2 March 2015
Ref 14365

**PROPOSED MIXED USE DEVELOPMENT
23-37 LINDFIELD AVENUE, LINDFIELD
TRAFFIC AND PARKING MATTERS**

**Drawing Title**  
**LOWER GROUND FLOOR PLAN**

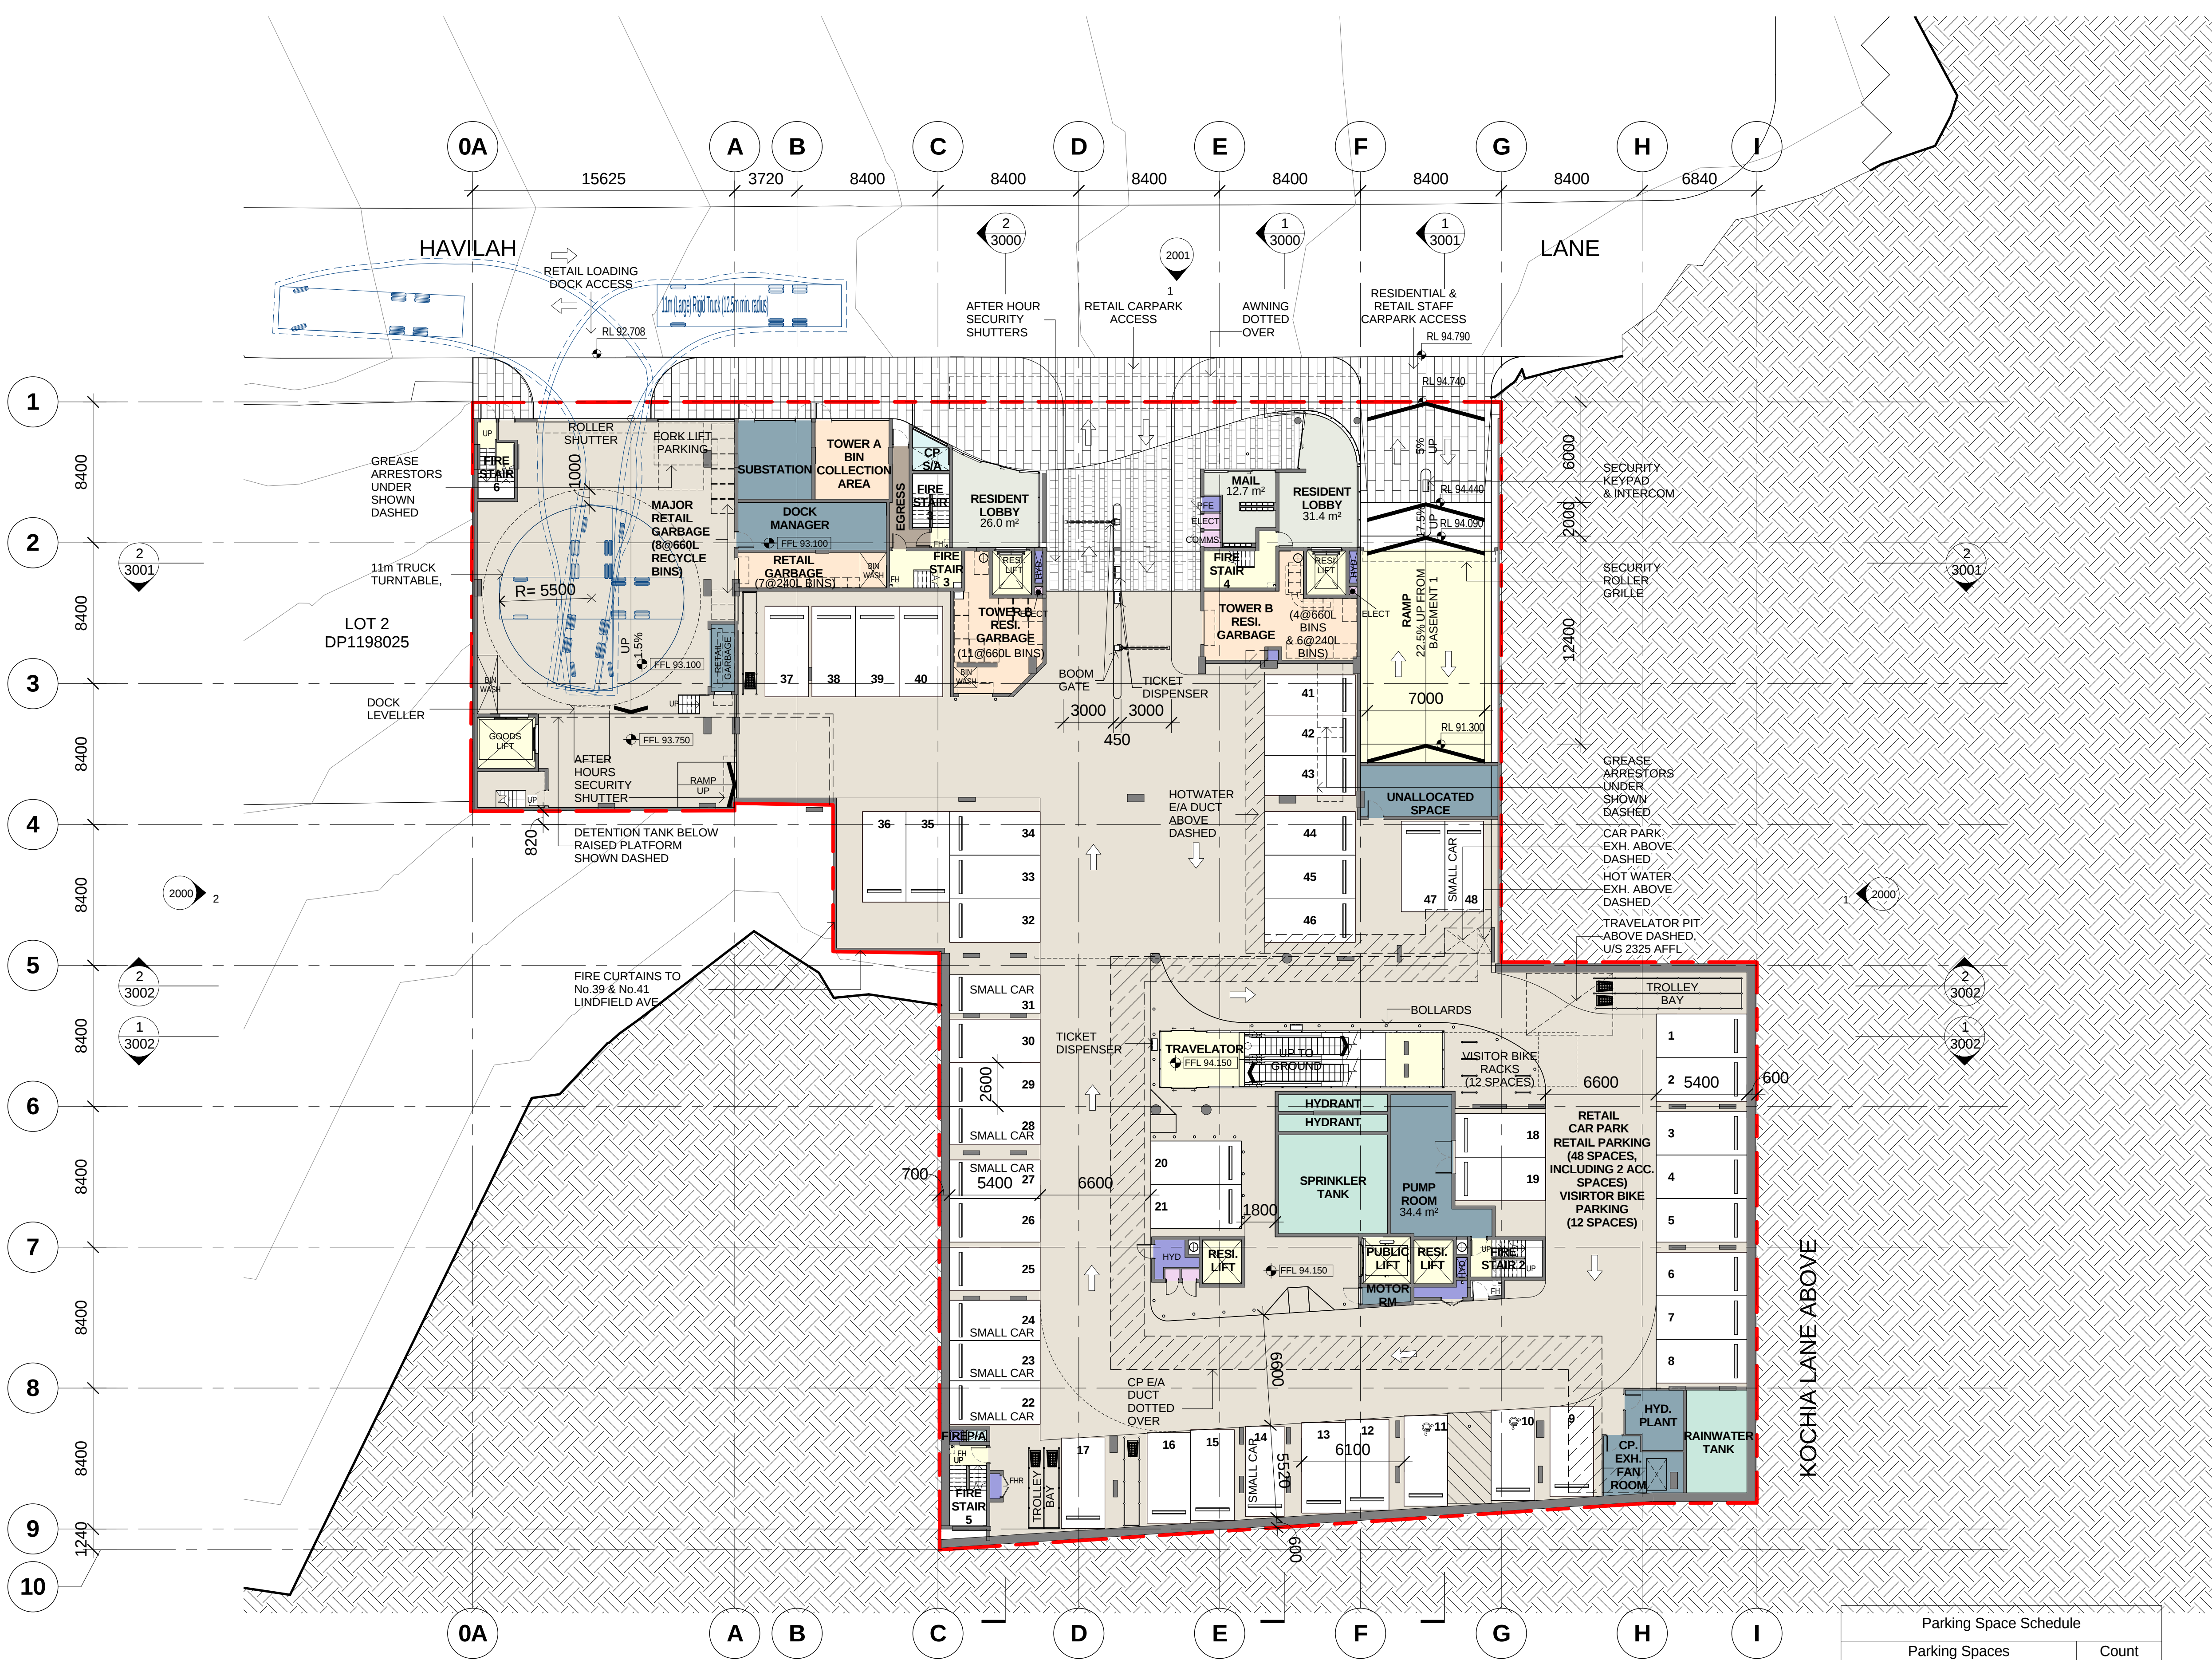
As you are probably aware, No's 39 and 41 Lindfield Avenue have recently been acquired by *Aqualand*. Consideration is therefore being given to increasing the area occupied by the lower ground floor level which would allow an increased number of retail parking spaces to be provided within the development.

The acquisition of the additional properties has allowed the vehicular access arrangements to be simplified, thereby enabling all of the retail parking spaces to be incorporated within the area controlled by boomgates to prevent all day commuter parking. This arrangement has also allowed the number of *small* car parking spaces to be reduced.

It is confirmed that the revised basement car parking layout is fully compliant with the geometric design layout requirements specified in the Standards Australia publication *Parking Facilities Part 1: Off-Street Car Parking AS2890.1 – 2004*.
